**Transport
for NSW**

Exhibition of Modification Request for Barangaroo Headland Park and Northern Cove Main Works, Barangaroo (MP 10_0048 MOD 8) - Demolition of Harbour Control Tower

CD16/02926

10 APPENDIX D – SWEEP PATH FOR MERRIMAN ST

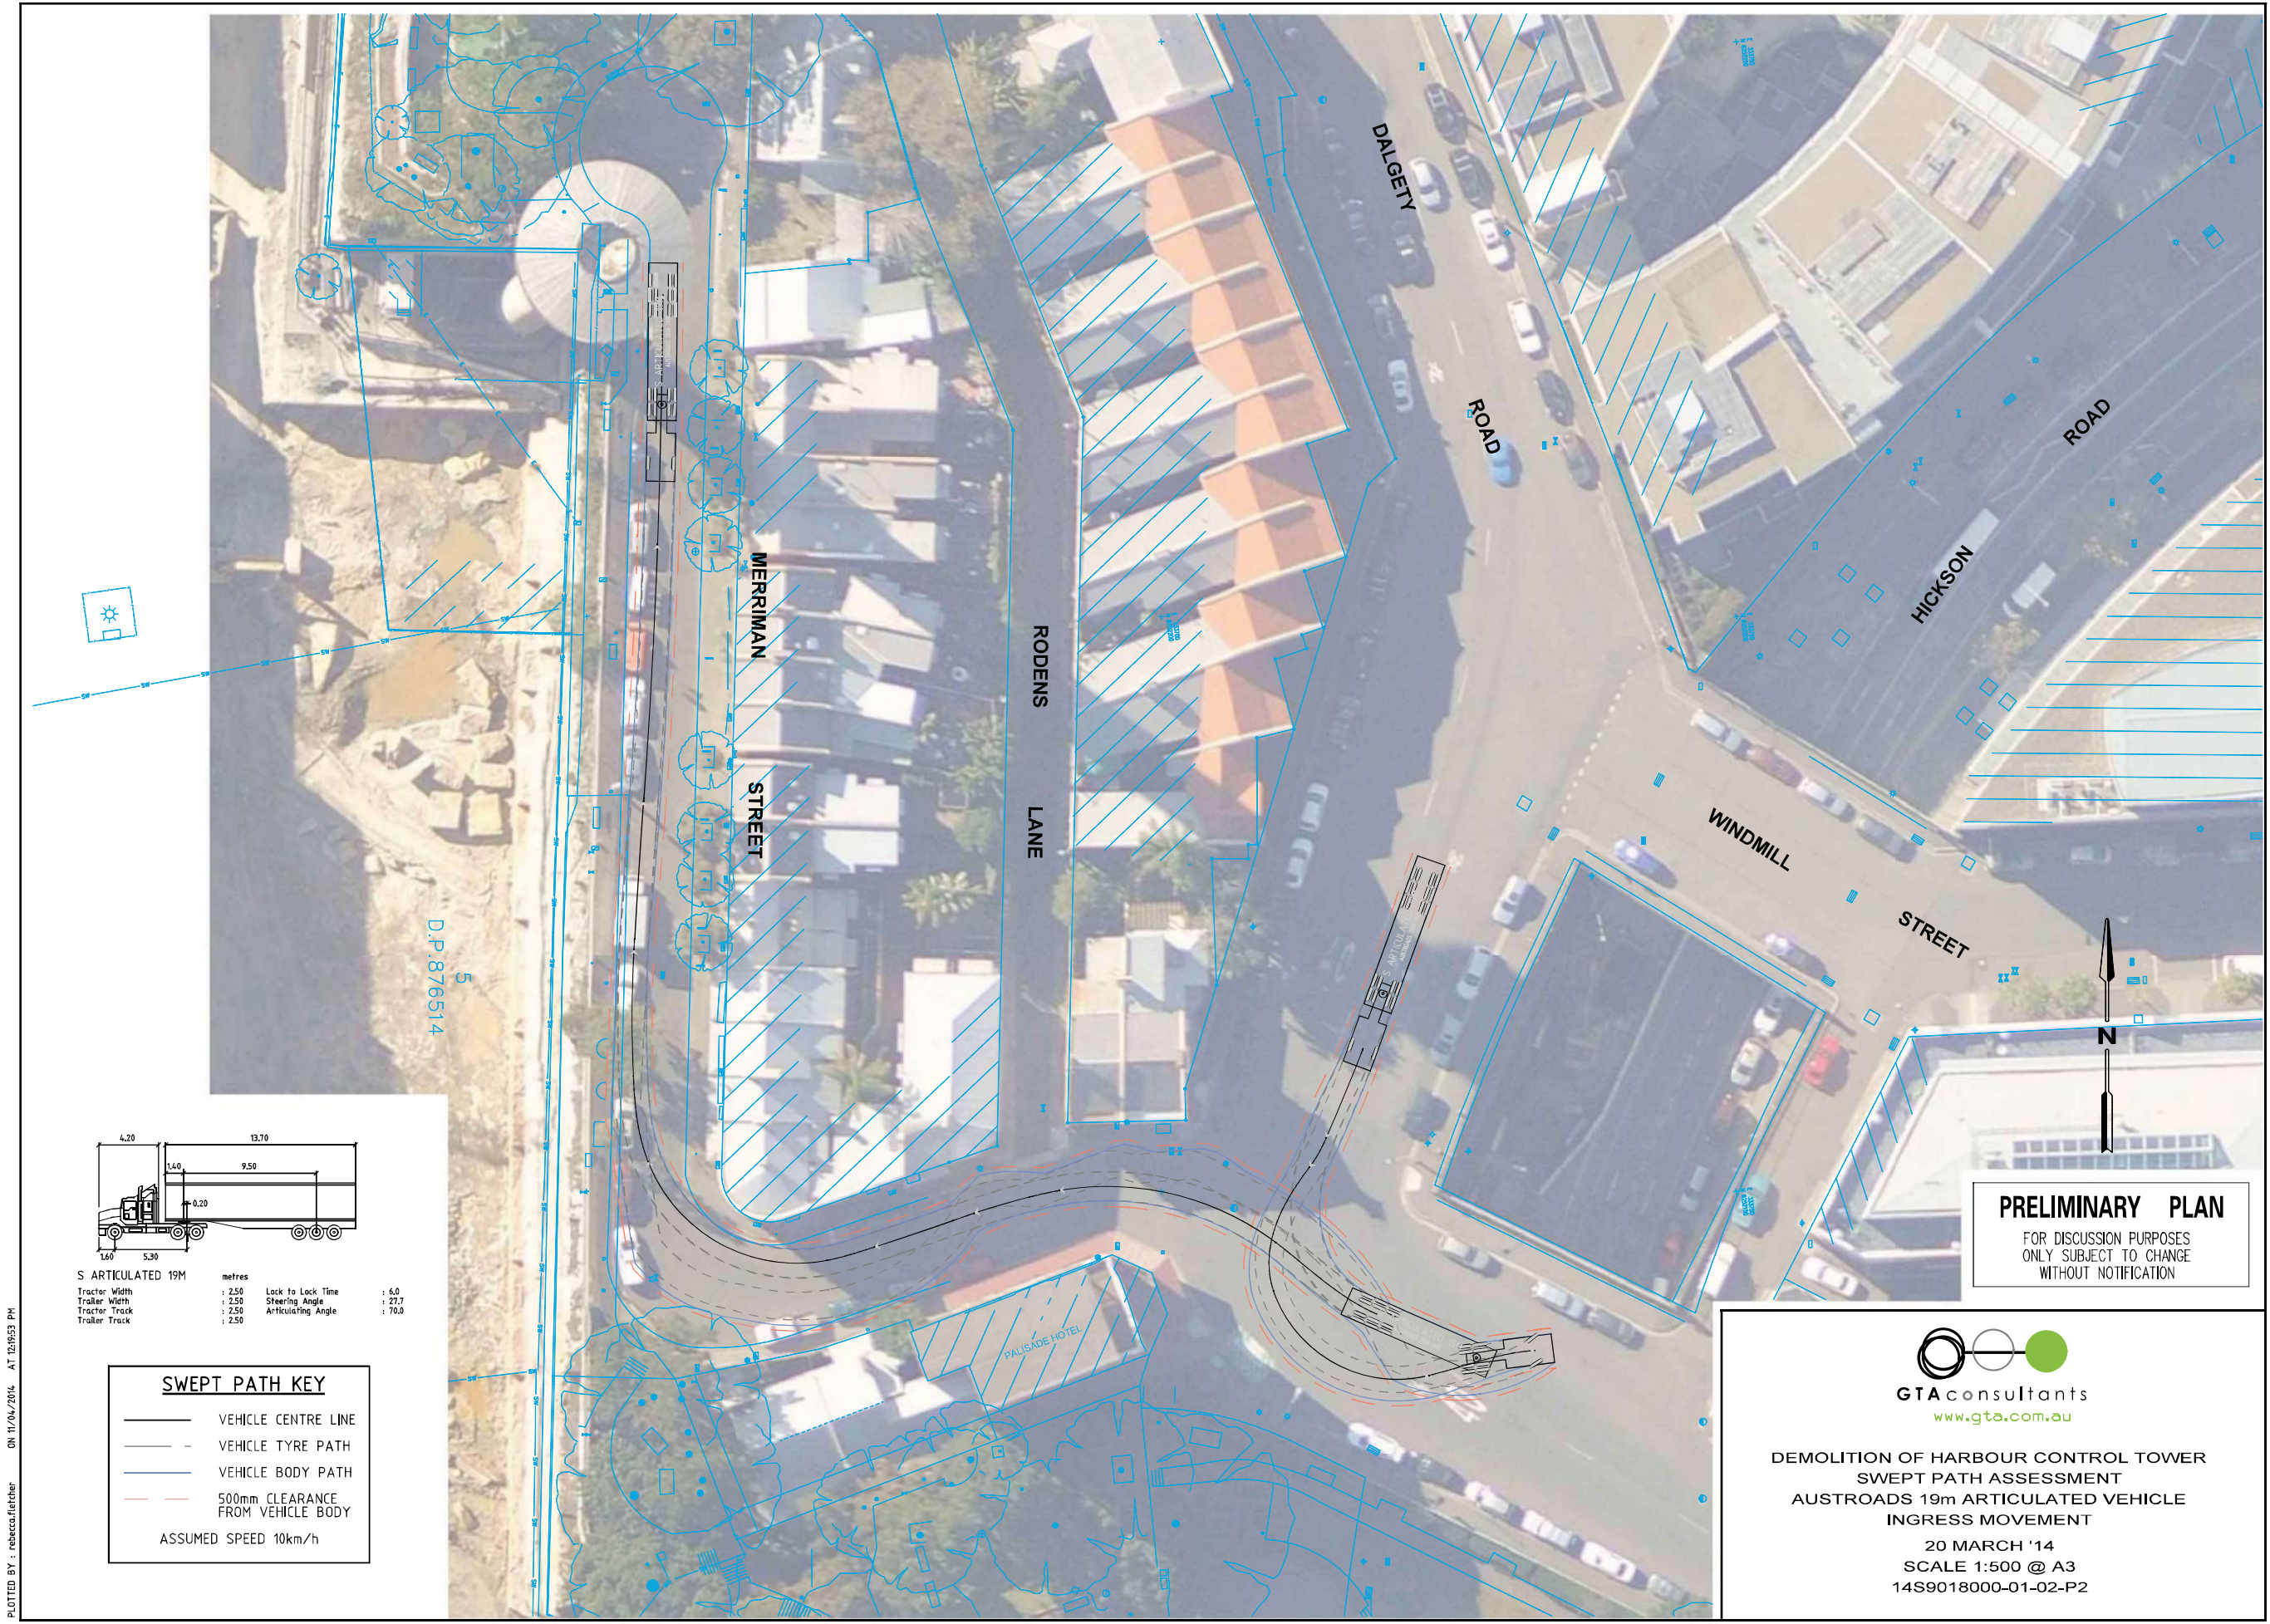
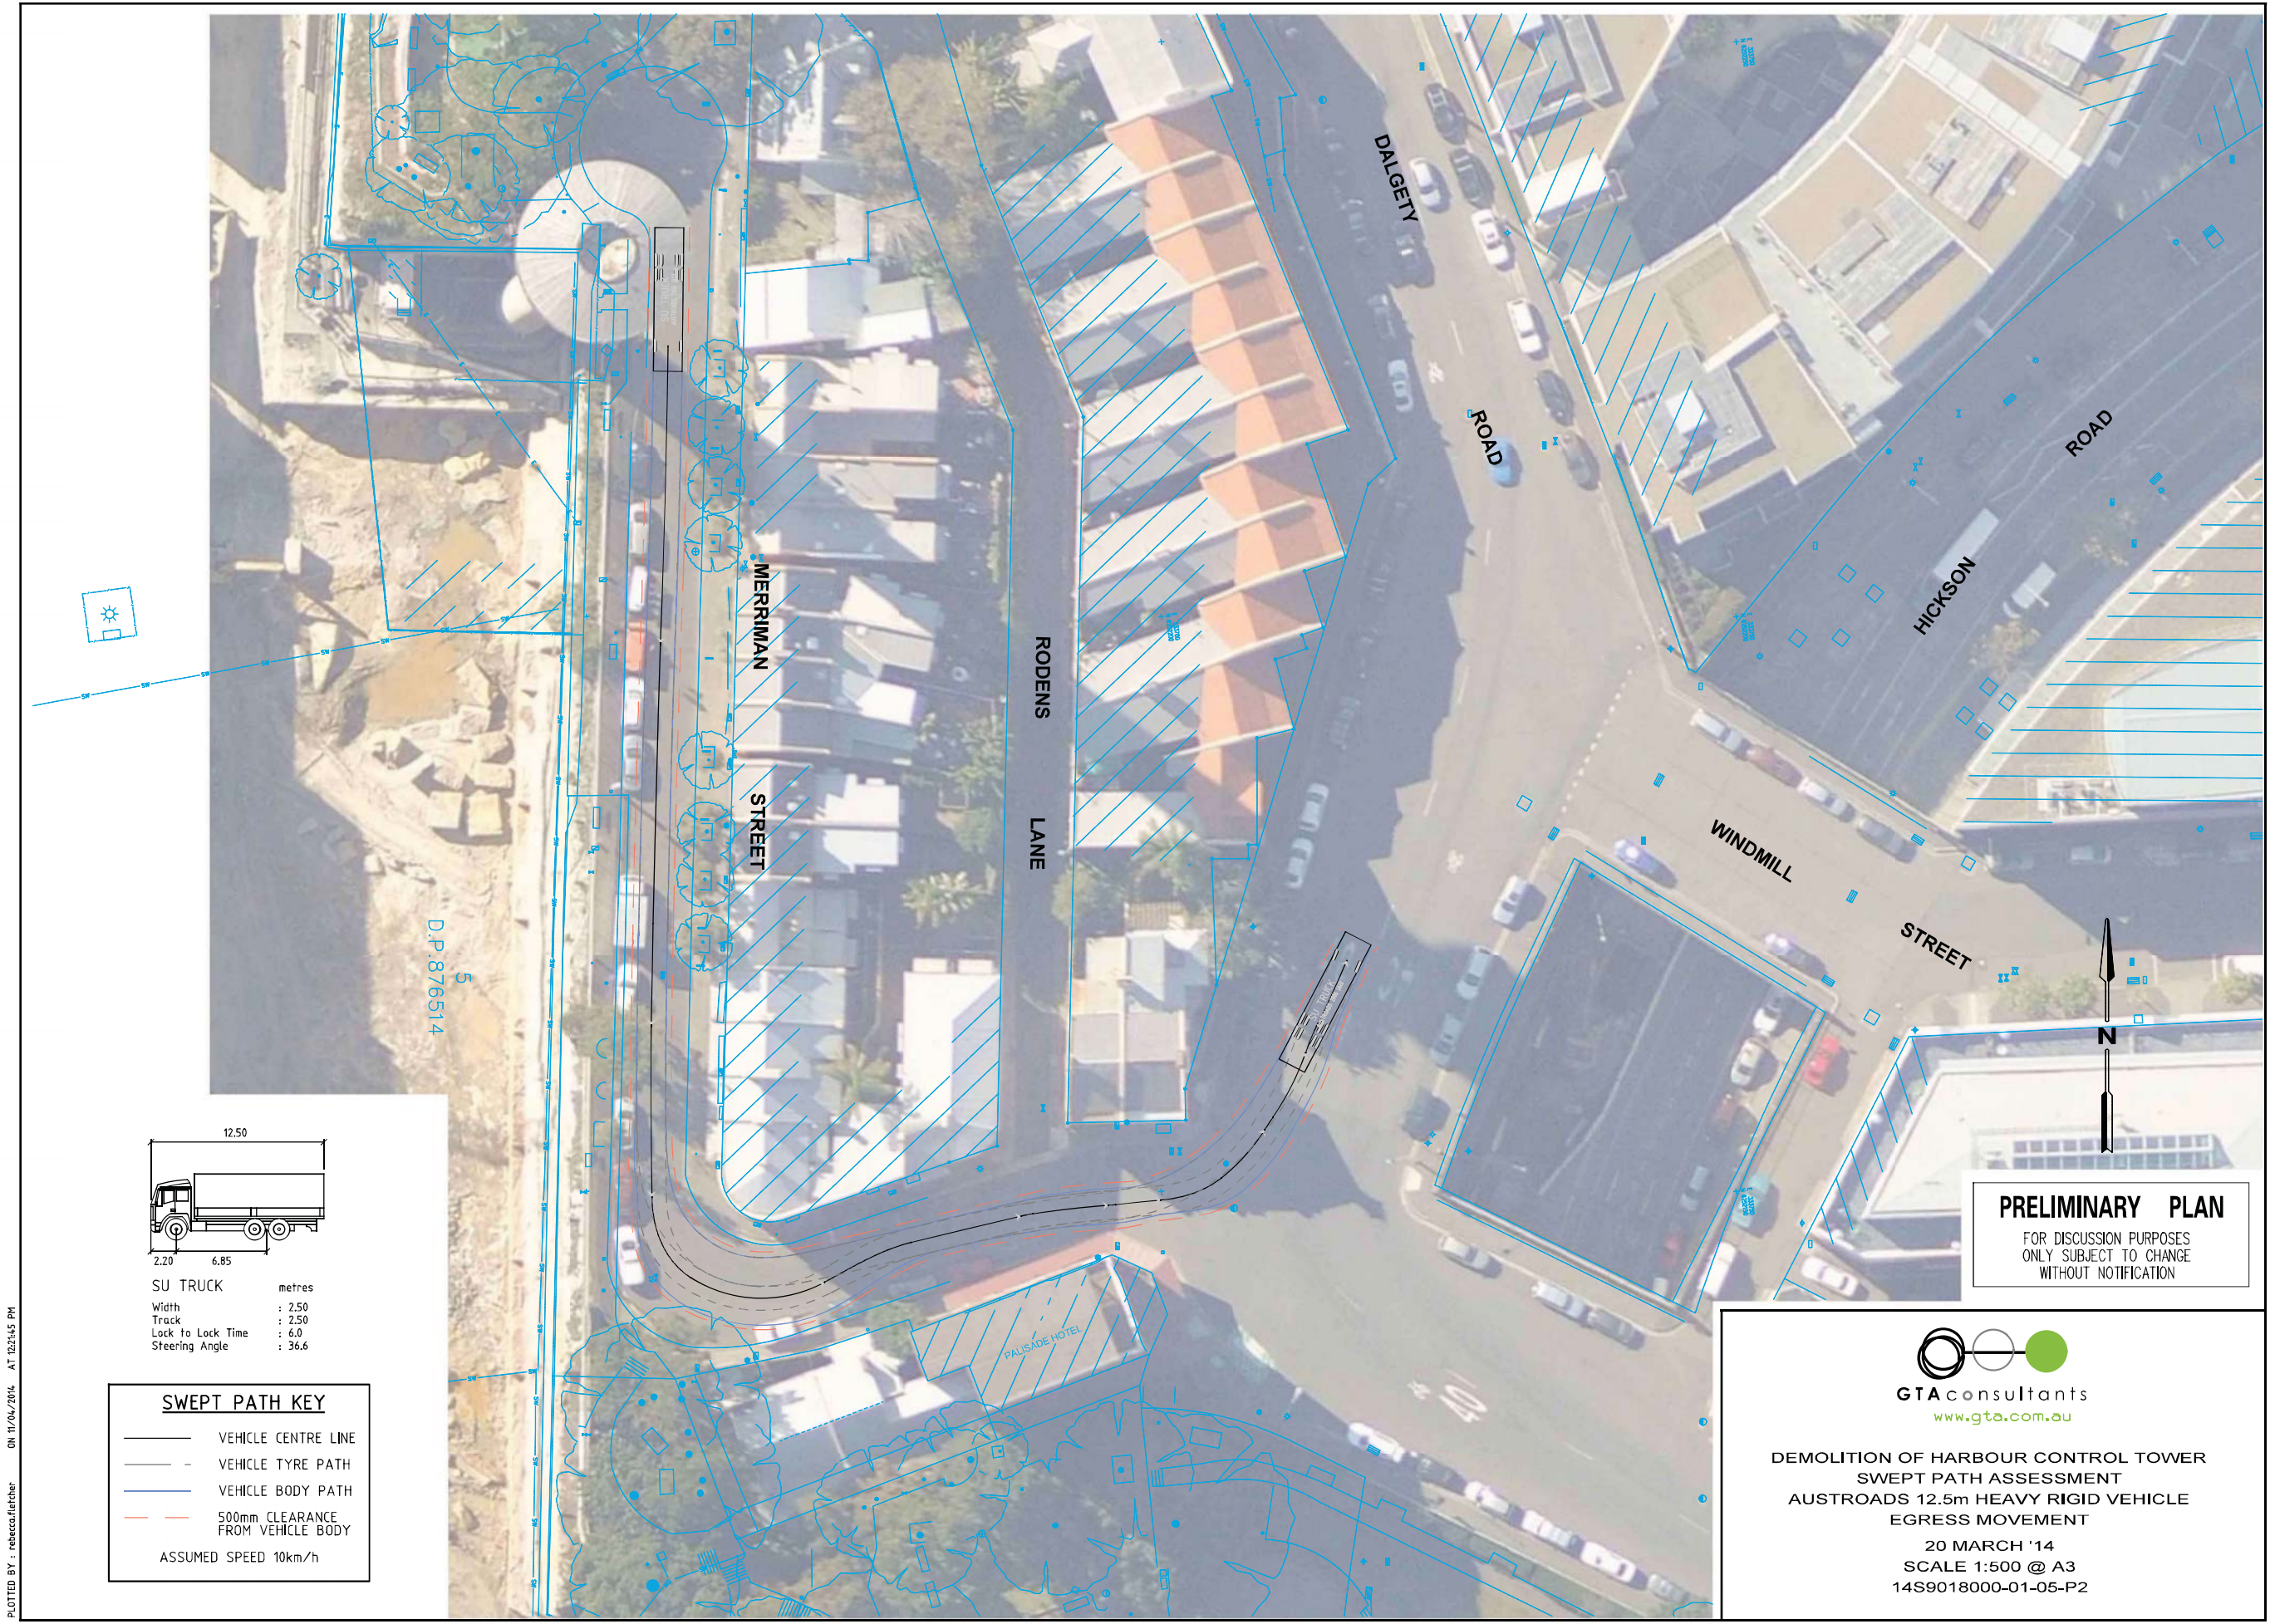
- Haulage route for vehicles accessing Merriman Street;
- Location of the loading dock in the cut-away;
- Estimated number and type of construction vehicle movements for all stages of work, including construction workers accessing the site, during peak periods and throughout the day;
- Swept path analysis for all construction vehicles into and out of Merriman Street and the cut-away;
- Proposed construction hours;
- Detailed assessment of the safety of Headland Park users during the demolition of the Harbour Control Tower;
- Construction program for each stage of the work;
- Details of the red light/ green light system that is proposed as a pedestrian safety measure for the cut-away exit for construction vehicles;
- Details of proposed measures for local residents accessing Merriman Street during the closure of Merriman Street;

TfNSW requests that the Traffic Management Plan be updated in consultation with the CBD Coordination Office within TfNSW and Roads and Maritime Services. The CTMP needs to specify, but not limited to, the following:
